WEST SUSSEX COUNTY COUNCIL CONSULTATION

TO:	Arun District Council FAO: Maria Tomalova
FROM:	WSCC - Highways Authority
DATE:	15 November 2021
LOCATION:	1 Como Barnham Road Chichester PO20 3RT
SUBJECT:	BN/142/21/PL Erection of a new two-storey building to contain 2 No 2 bedroom flats with associated parking, bin and bike stores and landscaping. This site is in CIL Zone 2 and is CIL Liable as new flats.
DATE OF SITE VISIT:	n/a
RECOMMENDATION:	Advice
S106 CONTRIBUTION TOTAL:	n/a

Ground Floor Plan

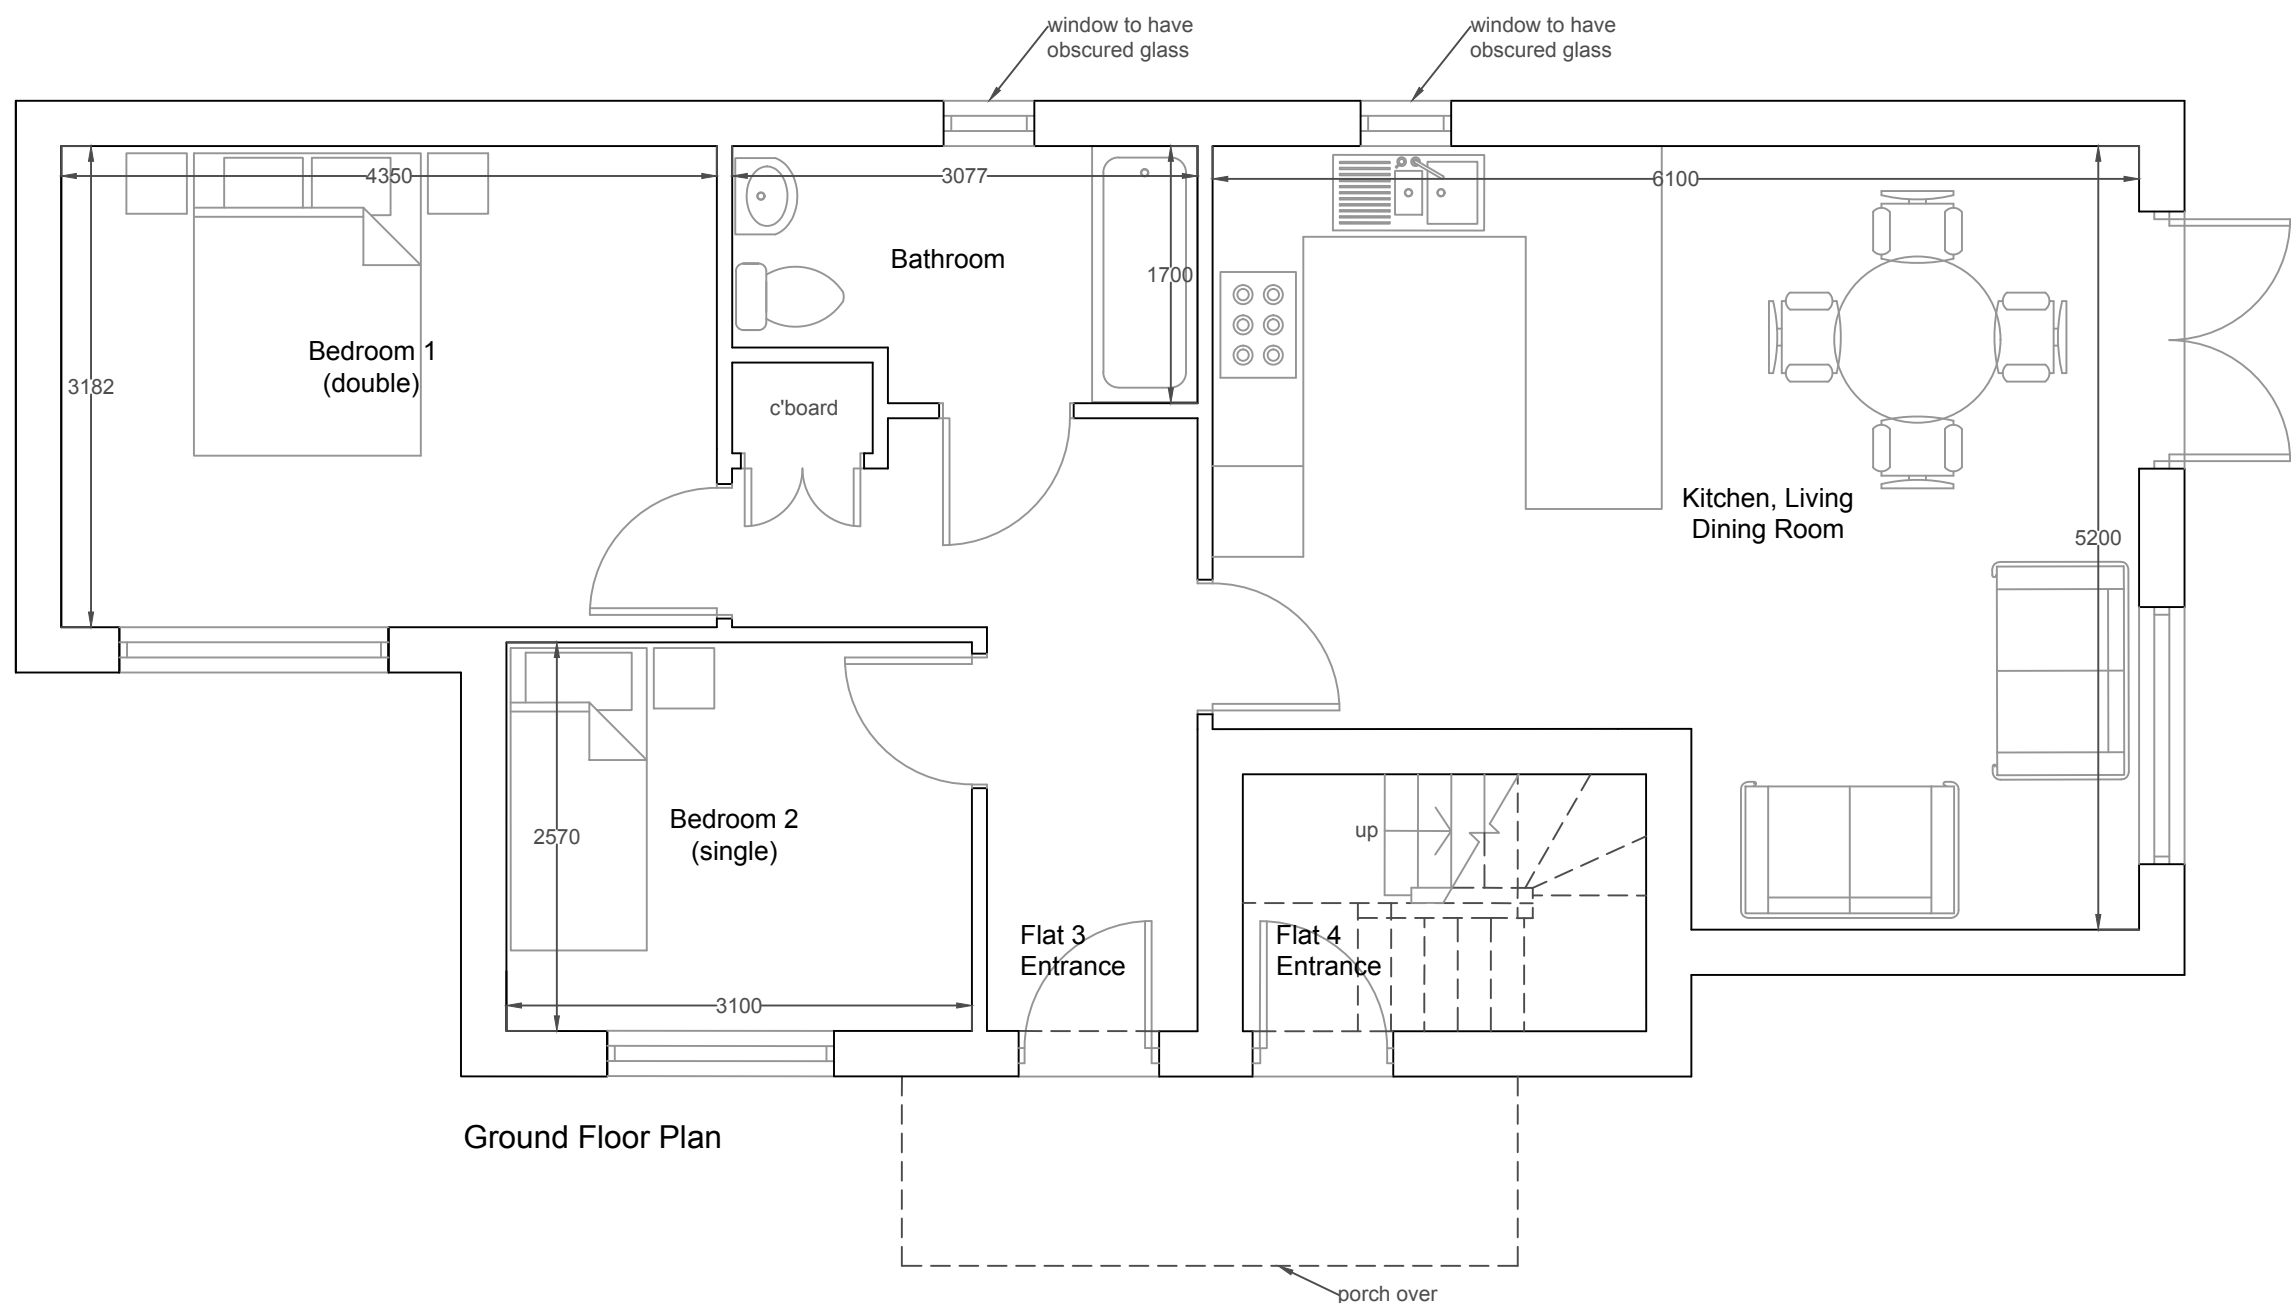
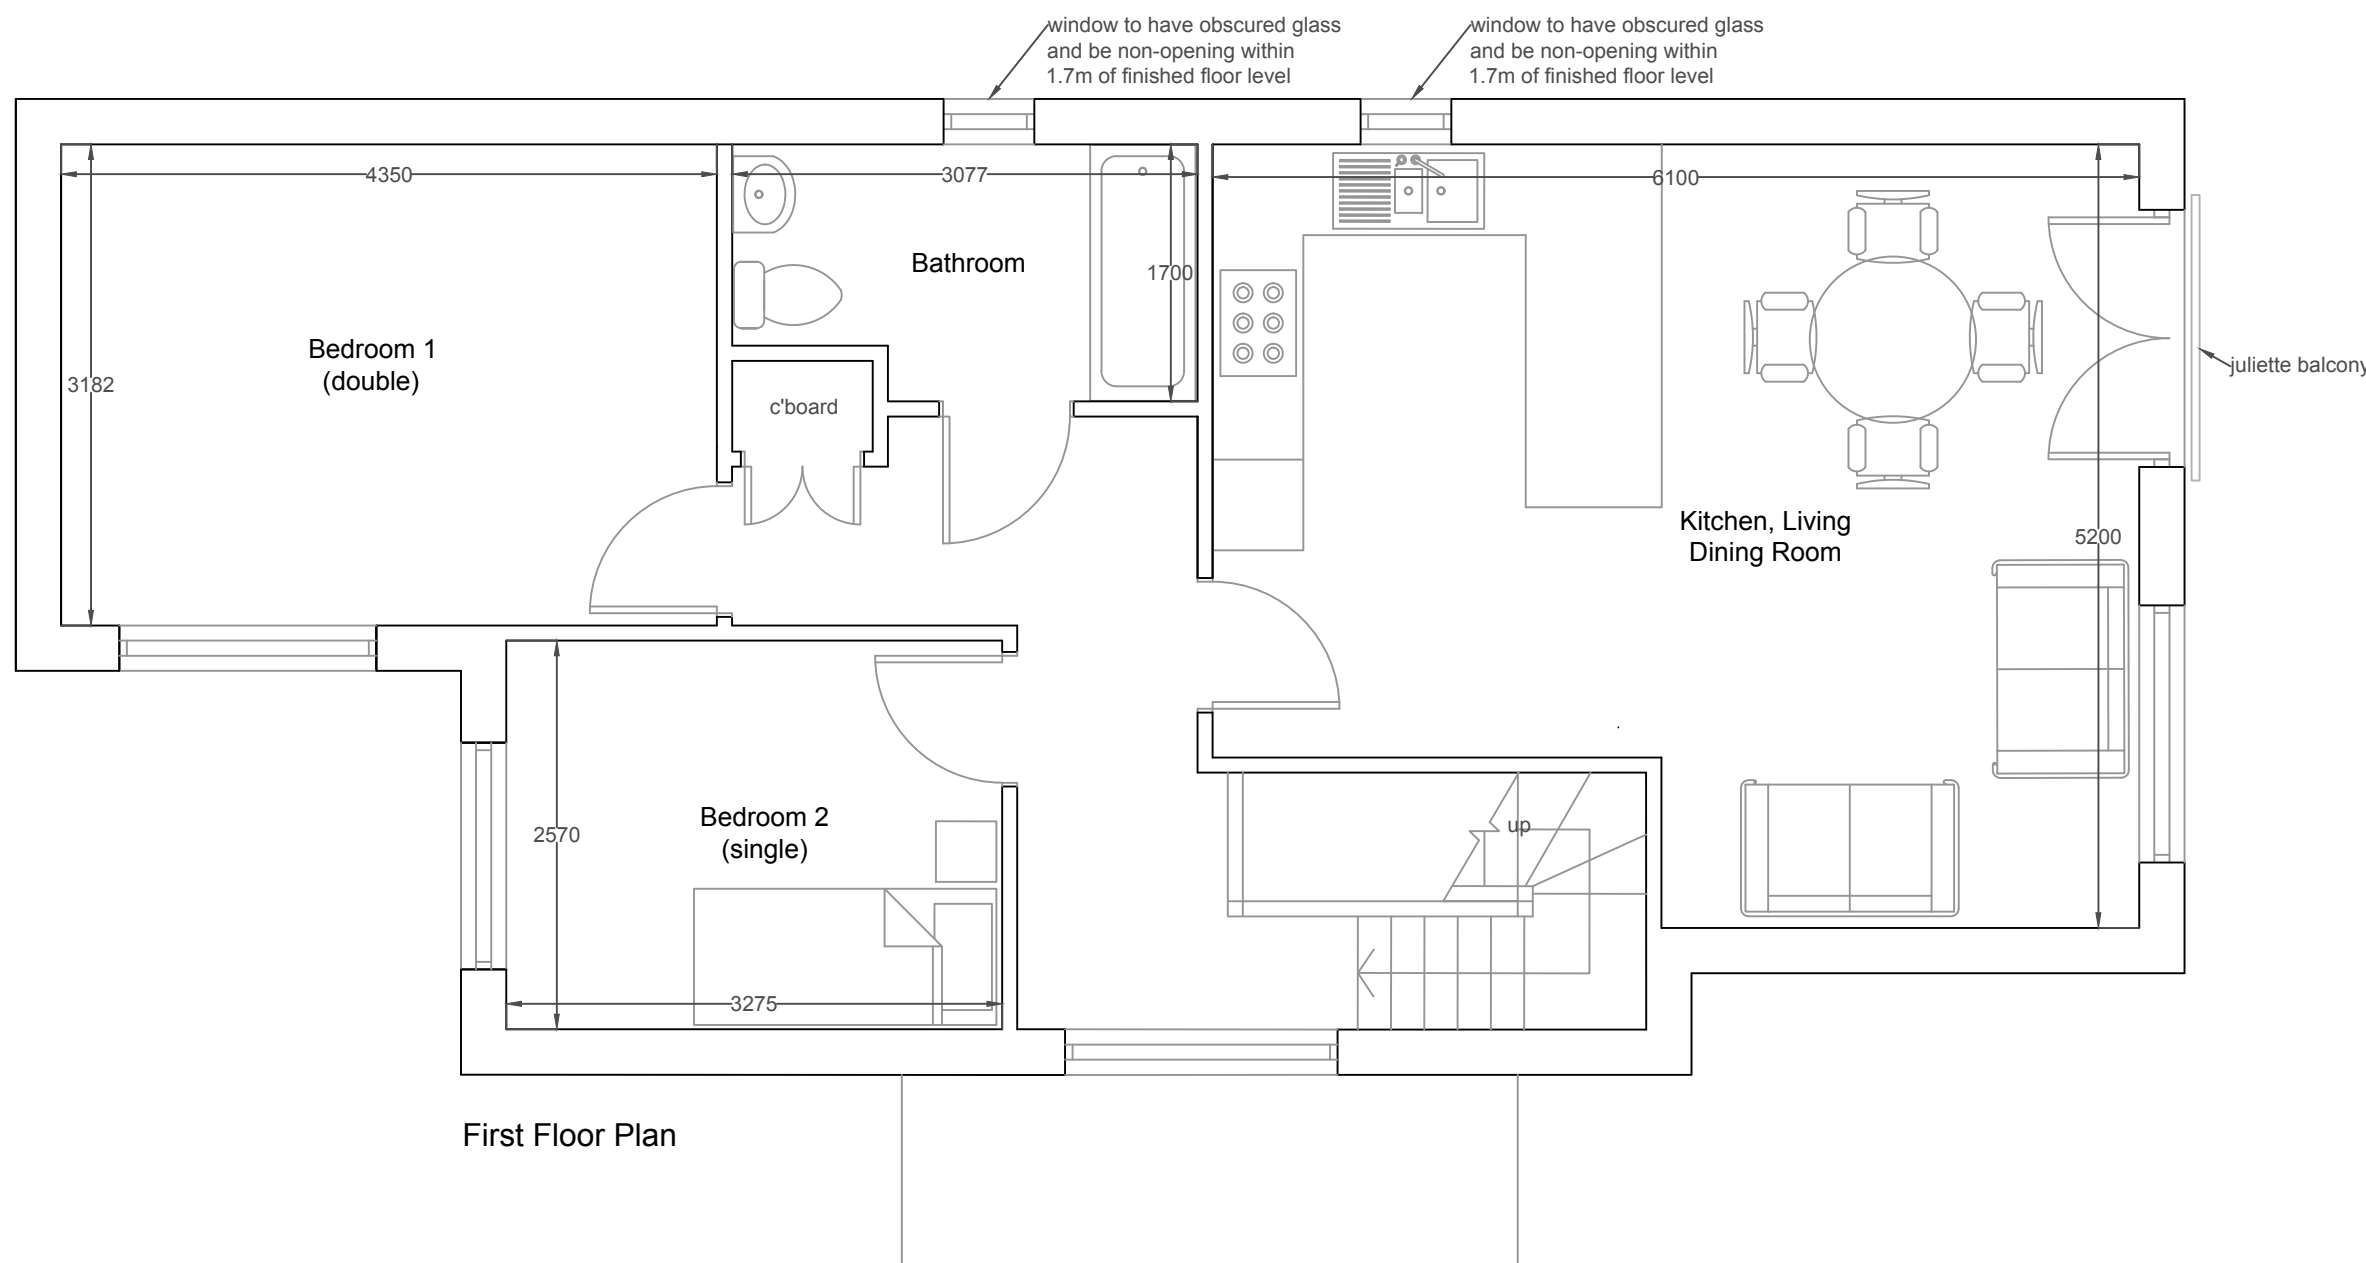
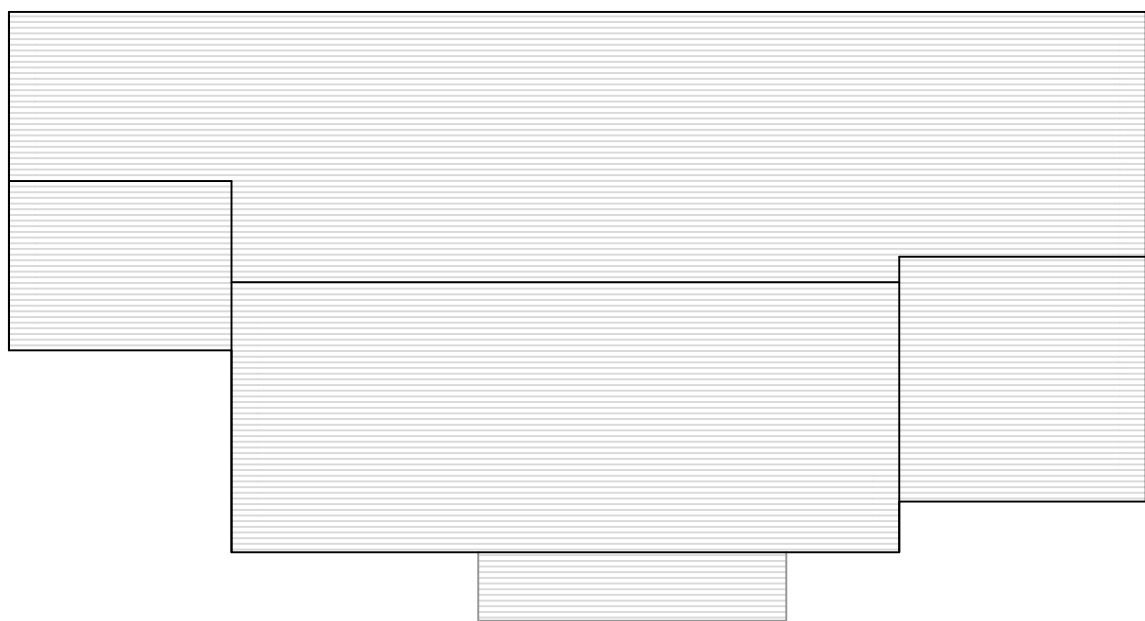
The proposed dwellings will be provided with one parking space each. Under the Arun Parking Standards SPD, a minimum of 2 parking spaces per dwelling would be required for a development of this size and location. The applicant is advised to consider whether any additional parking provision could be accommodated on site to reduce the potential of overspill parking demand being accommodated on-street. The LPA may wish to consider the potential impacts of this proposal on on-street parking from an amenity point of view.

The proposed plans do not demonstrate that vehicles can turn on site, however the LHA considers that there appears to be sufficient space on site for vehicles to turn and exit onto the public highway in a forward gear.

No part of the development shall be first occupied until the car parking has been constructed in accordance with the approved site plan. These spaces shall thereafter be retained at all times for their designated purpose.
